LSC Responses to EPC TIS Redline Comments

Saddlehorn Ranch Traffic Impact Analysis PCD File No. SP-19-006 (LSC #184751) March 11, 2020

# Roadways to be Constructed by Subdivision Filing

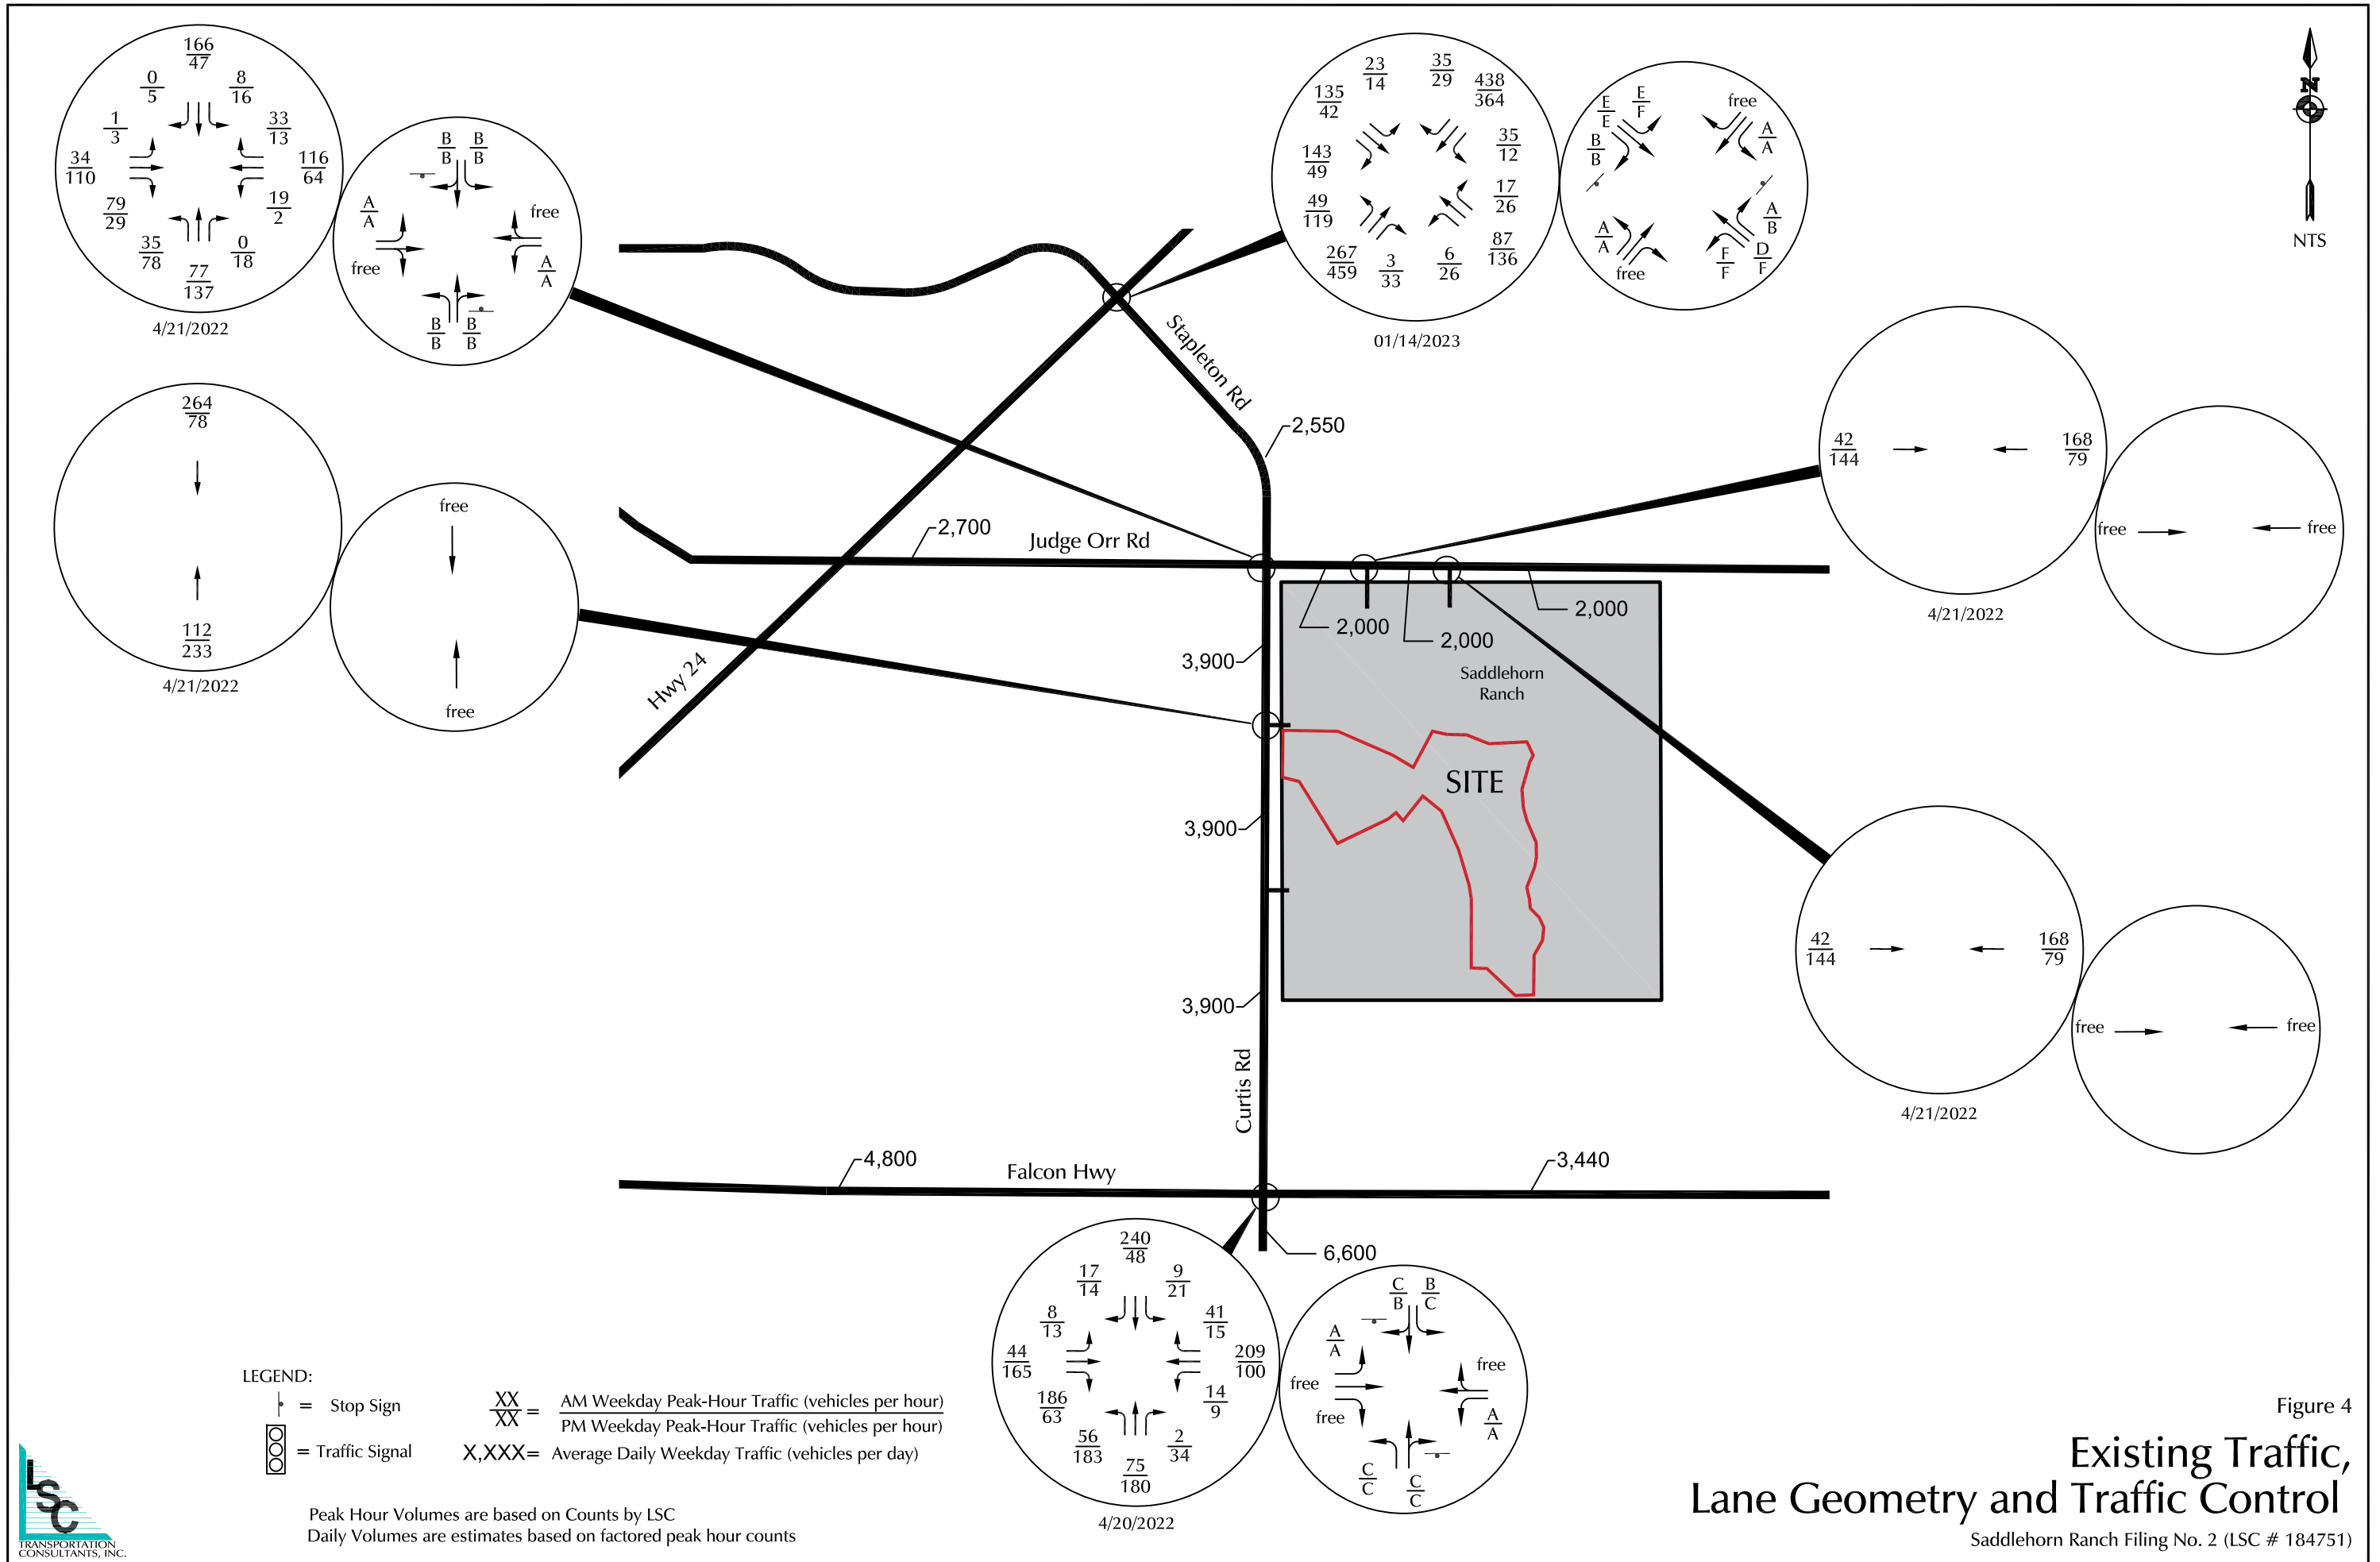
[Remove Filing 3 label](#)

LSC Response: Removed.

# 2042 Total Traffic, Lane Geometry, and Traffic Control

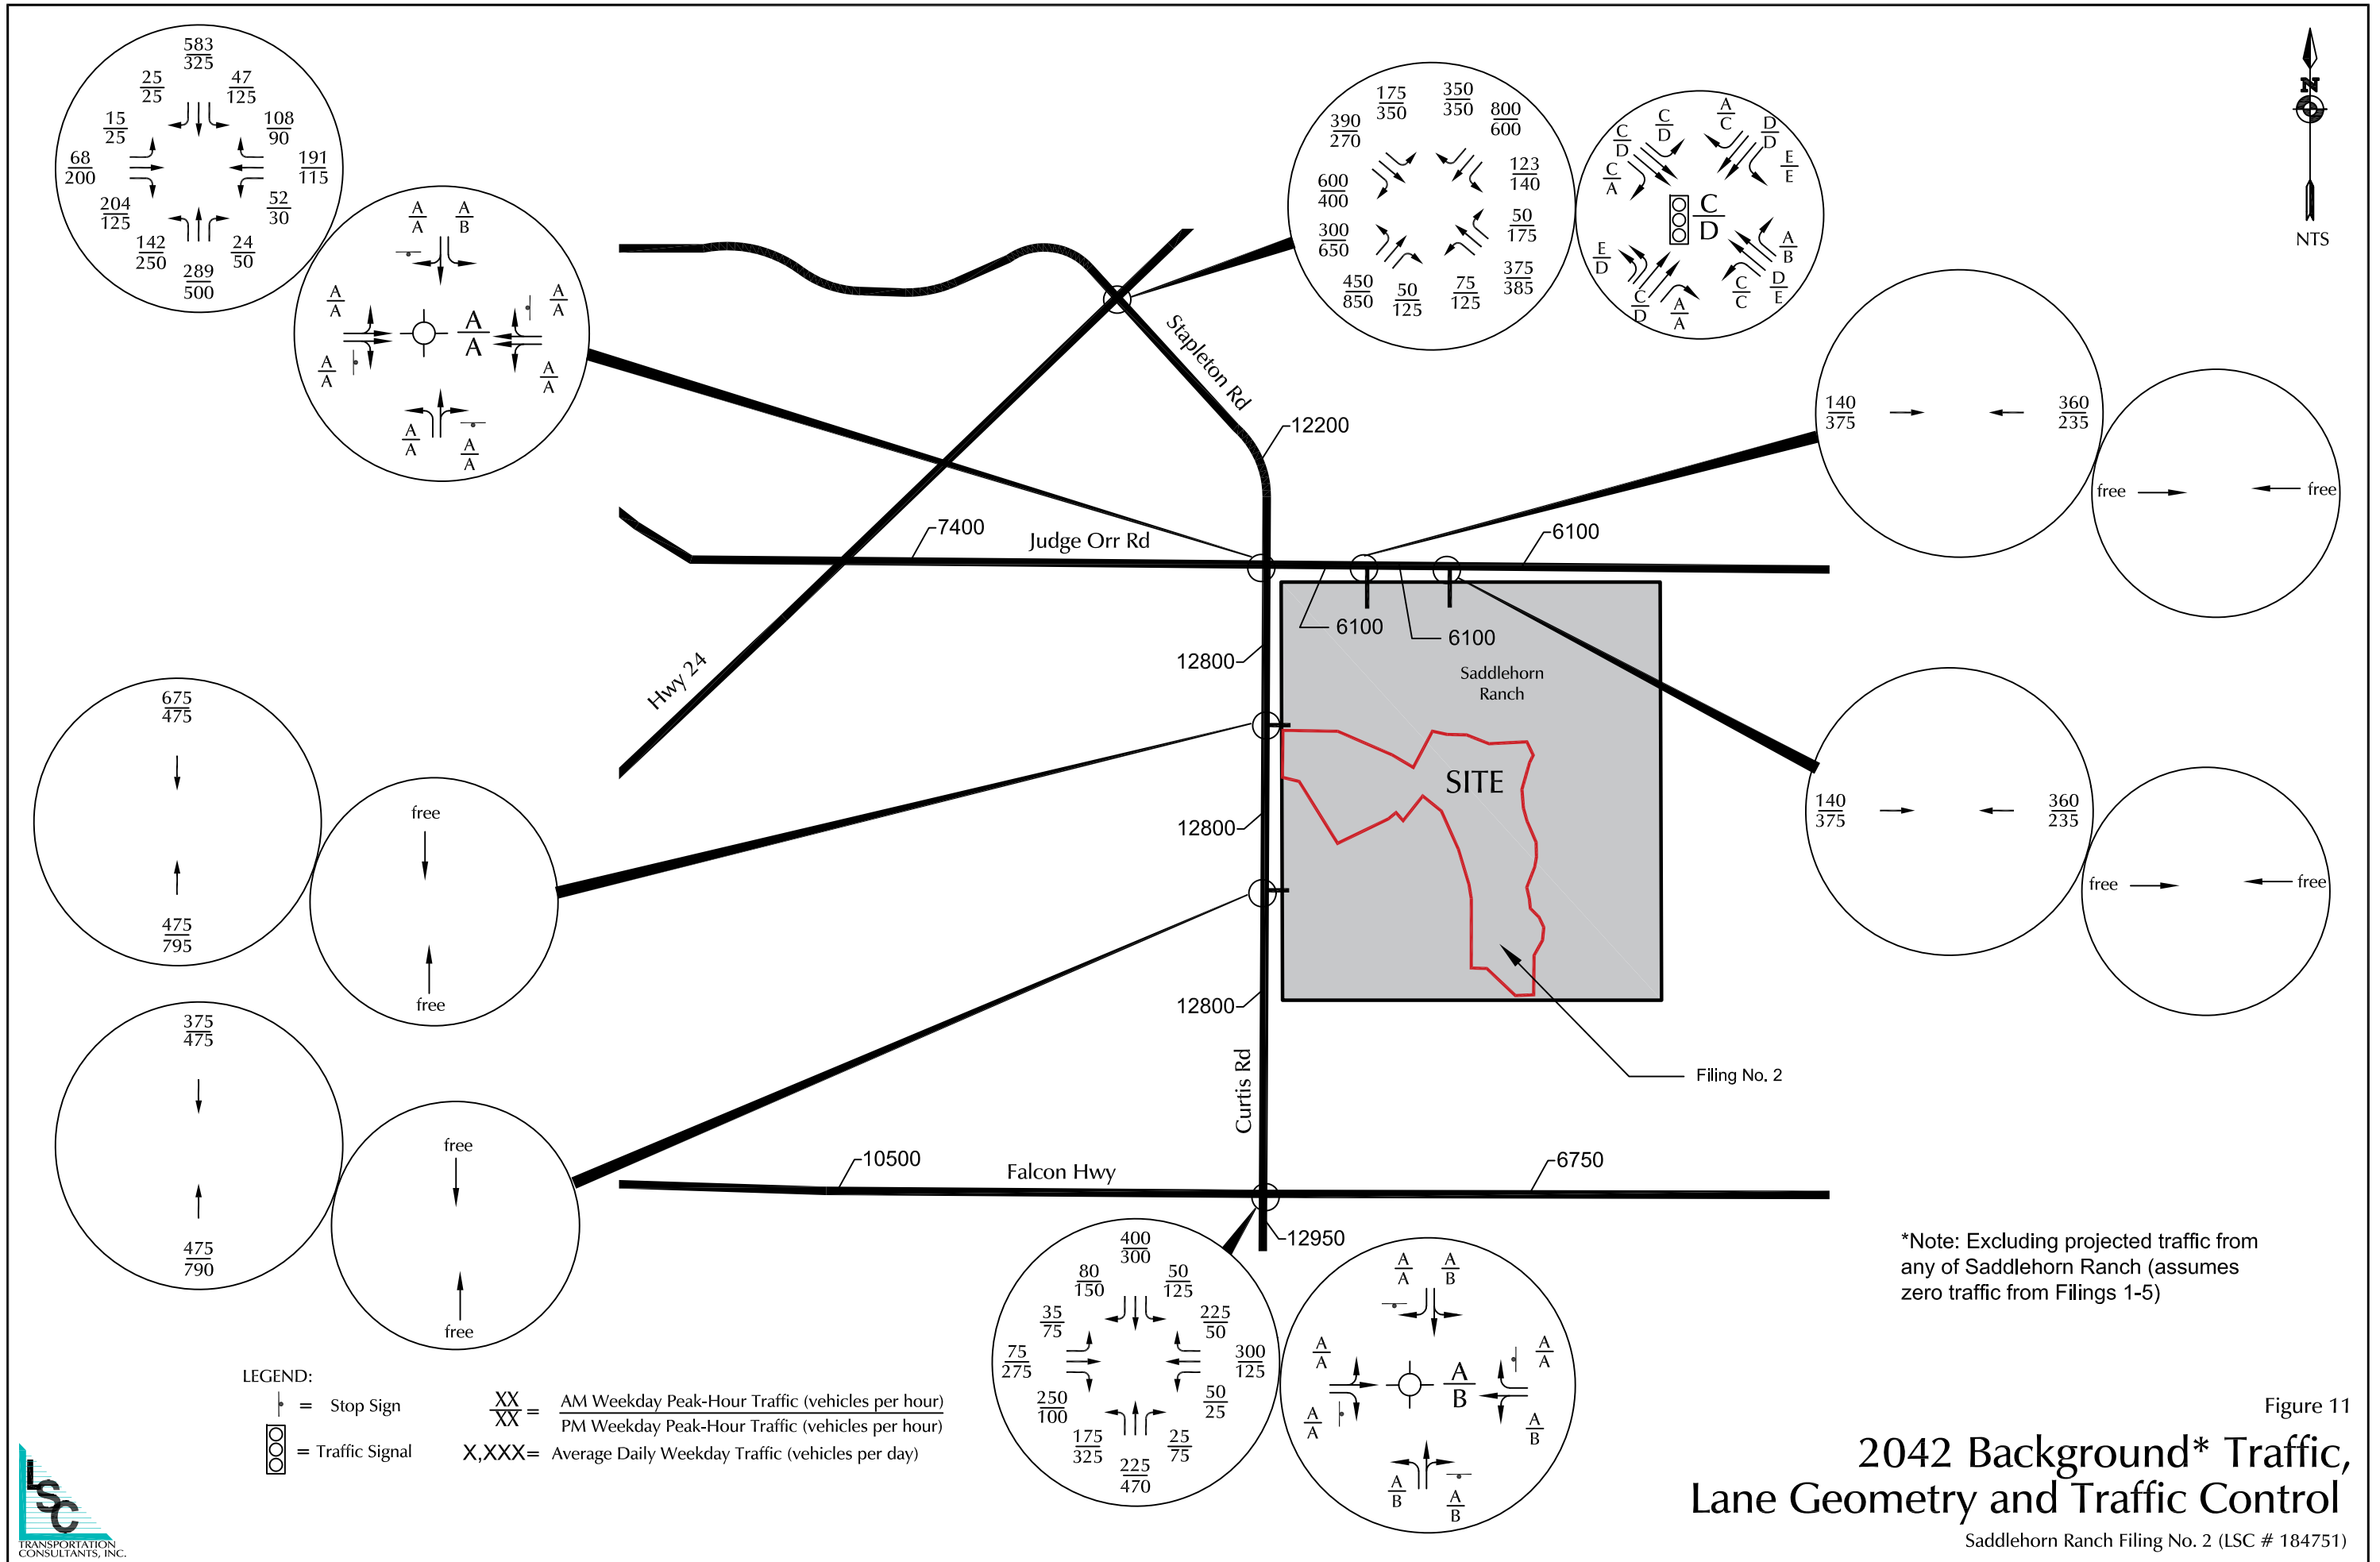
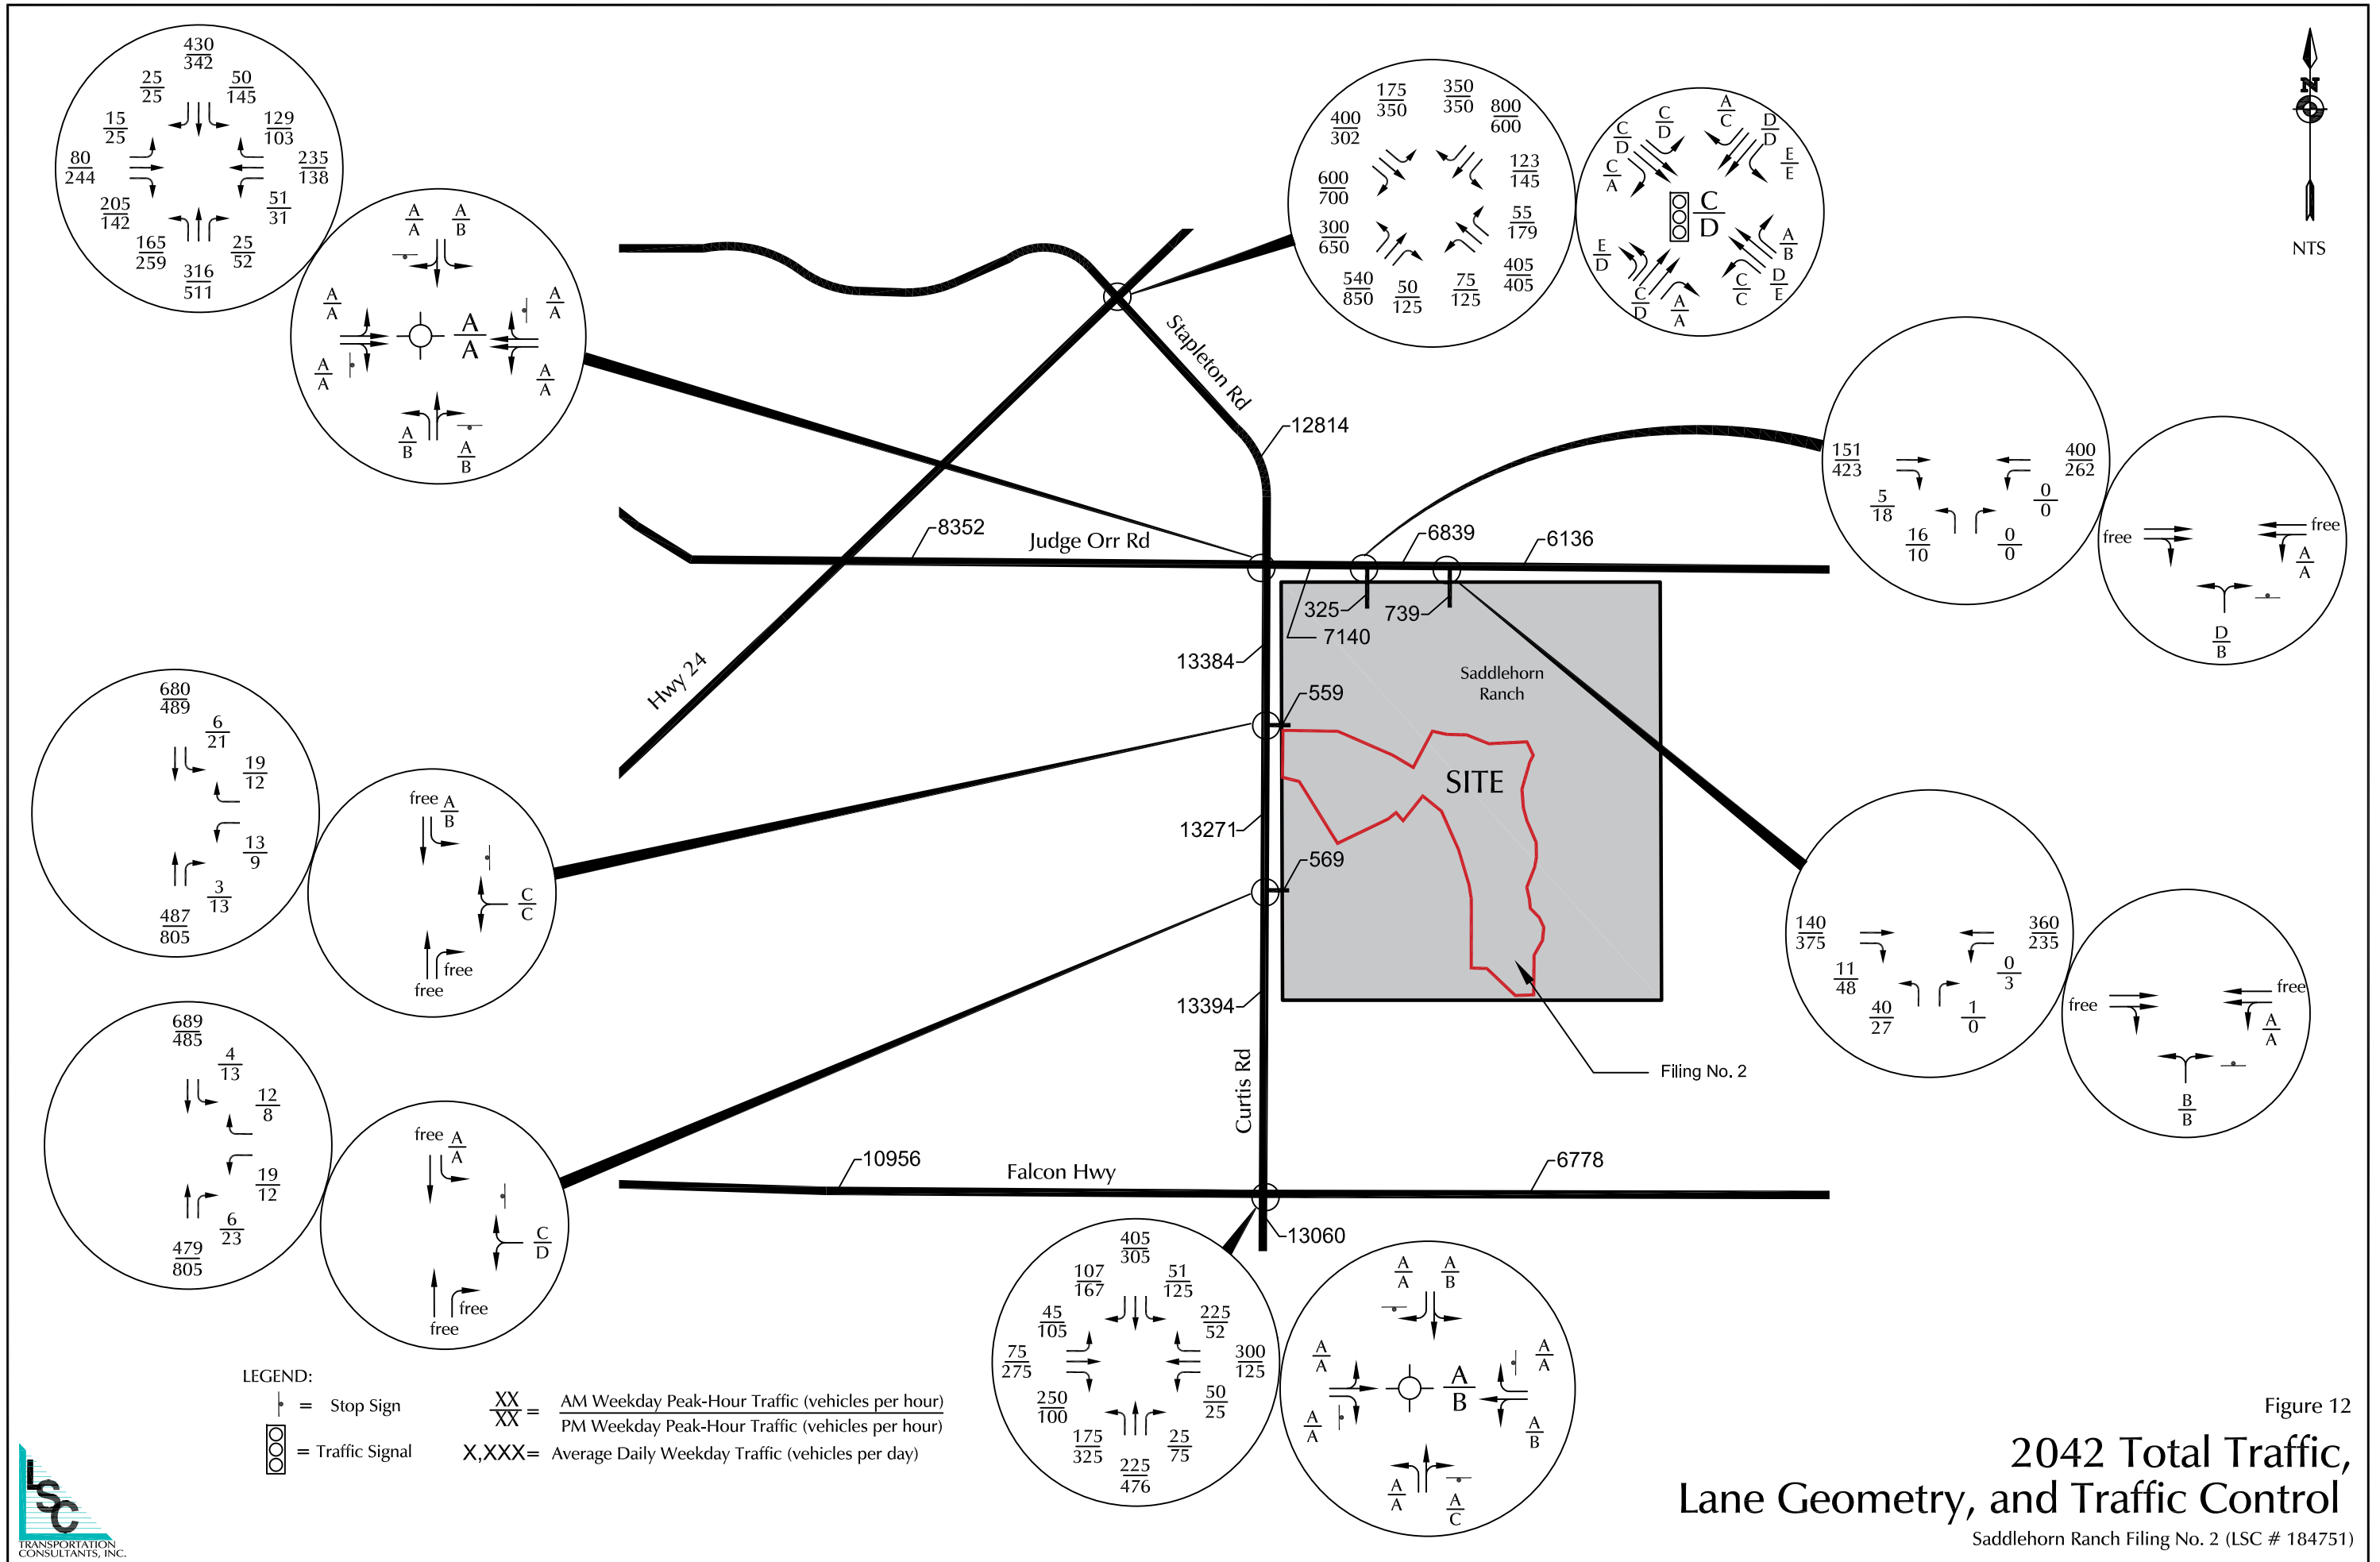
[Figures & LOS reports show 2042. Please revise accordingly so all items reference same year](#)

LSC Response: Figures and LOS Reports have been revised to show 2043.
